Application No: P/96/22/HH
Site Address: 97 Harbour View Road Pagham PO21 4RJ
Description of works: Erection of single storey outbuilding to rear.

Thank you for your internet representation made on 21st July 2022 which has been recorded as an objection with the comments as follows:

ALL AS PROPOSED.
1:100.

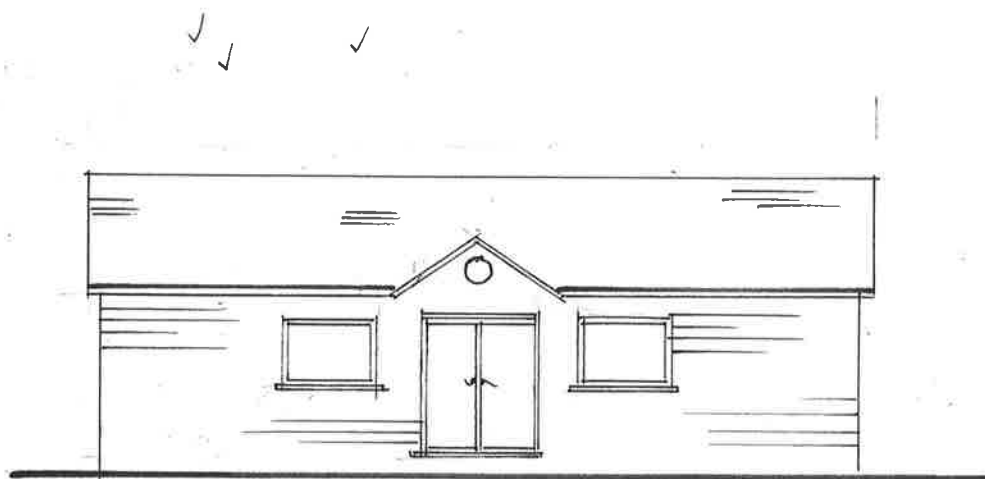
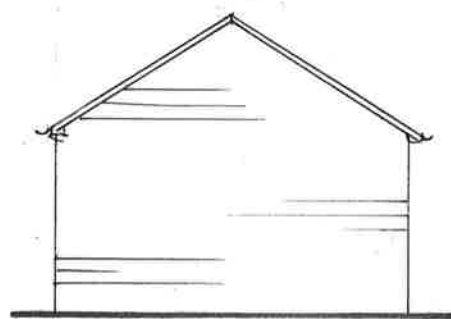
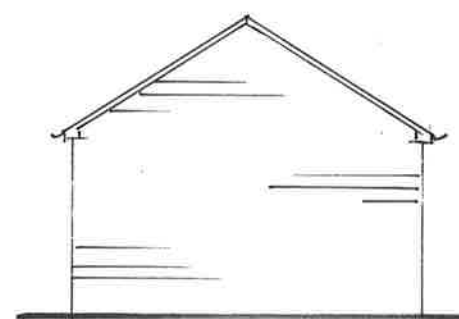
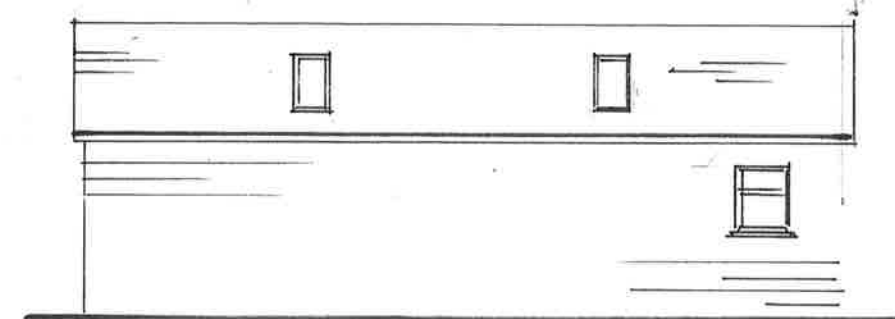
This proposed out building will be the view at the end of my garden, blocking sunlight as not flat roof and potential of using as a business as shower and toilet planned.
The height of roof will be an eyesore and block sunlight.
There are also trees in neighbours garden, 1 Baron Mead, that are in the back fence line which has not been stated in the plans .
Completely ruin the end of my garden from height and size
